Our overall position in Raydon is that the proposed works will have a considerable and long term effect on the residents and businesses in and around Raydon. Our priority is for NG to fully consider an off shore solution. Failing that a proper consultation on the HVDC options for the full

Below we list a series of detailed comments and considerations in response to the consultation, noting the significant shortfall in consultation documents and details at this stage.

THE NATIONAL GRID
(NORWICH TO TILBURY) ORDER
INDICATIVE HIGHWAY MITIGATION PLANS
SECTION C (SHEET 6 OF 15,
BABERGH DISTRICT COUNCIL)

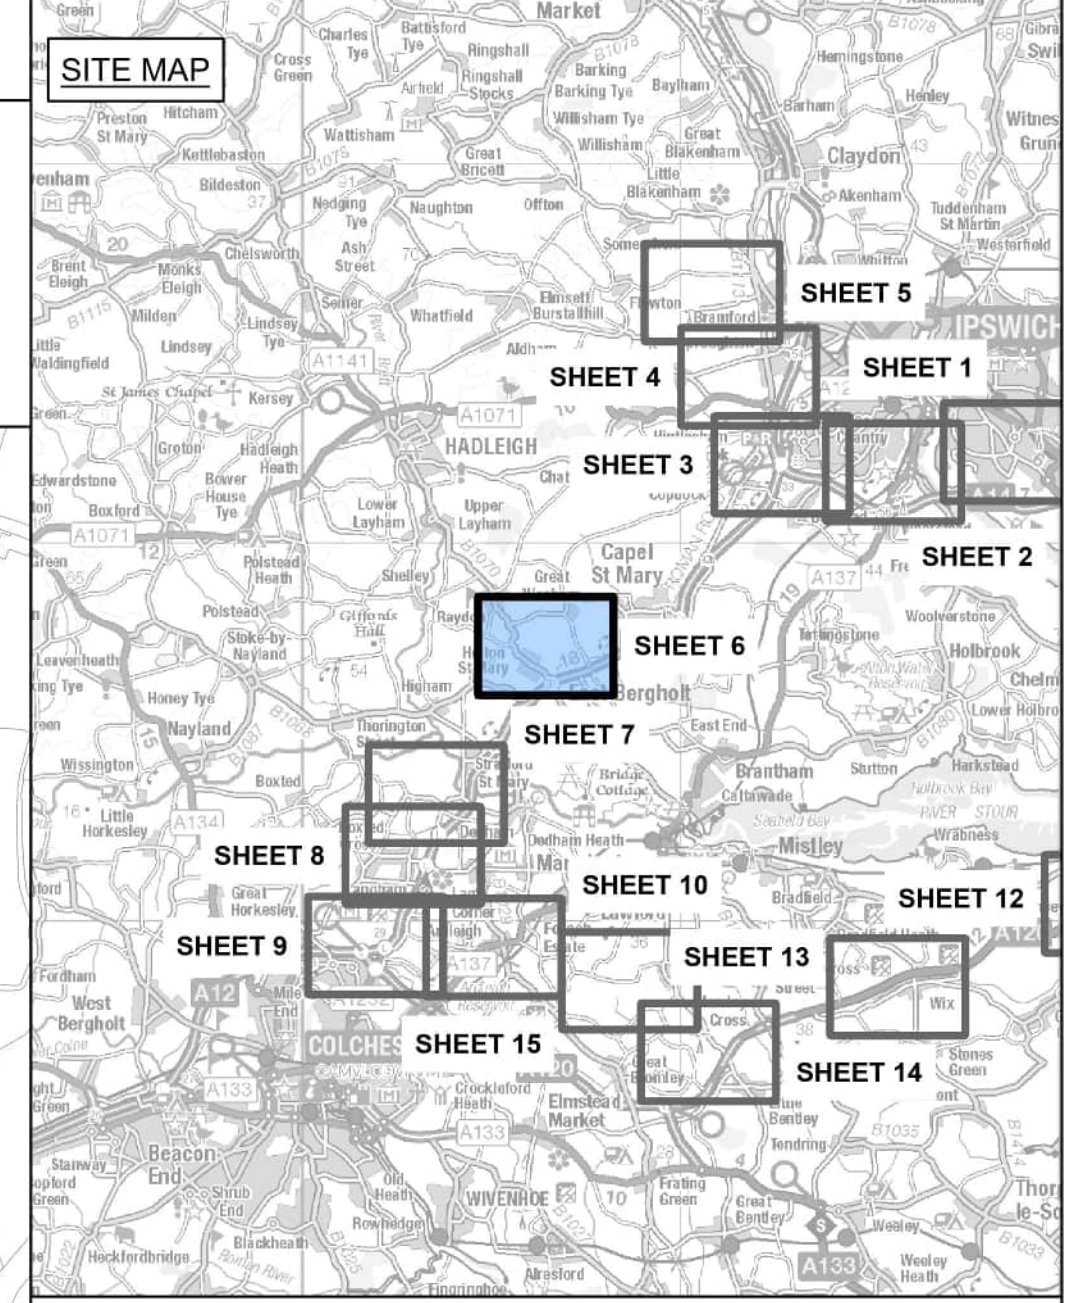
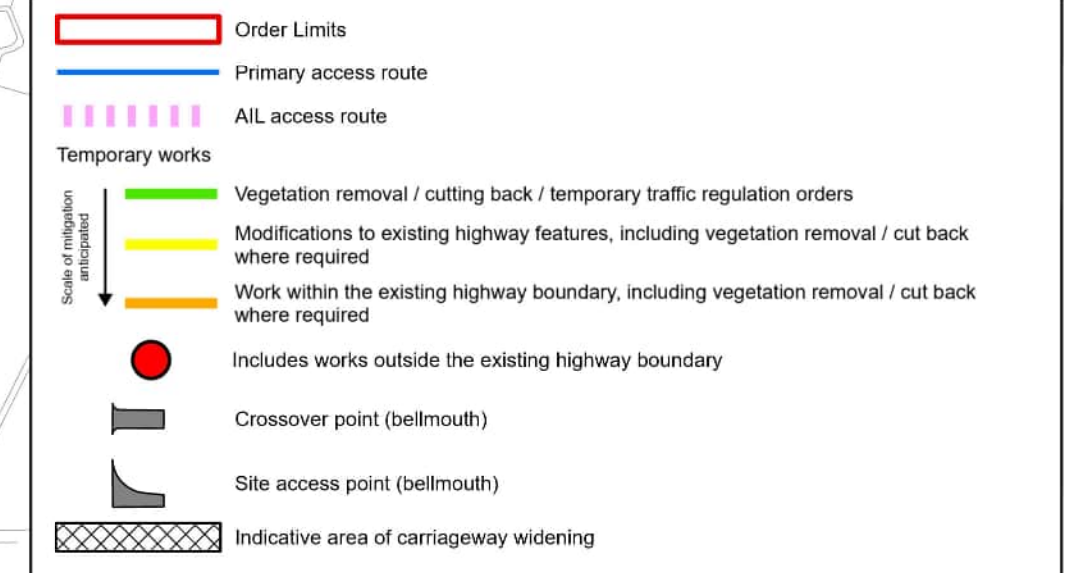
Crossing B1070 - Anglia Water's ongoing new NSIP pipeline works have not closed the B1070 apart from two weekends. We seek confirmation that the NG works will not disrupt traffic on the B1070 or result in diversions on Quiet Lanes and unclassified roads. - Local roads cannot take diverted traffic. Active management of such works will be required. See below.
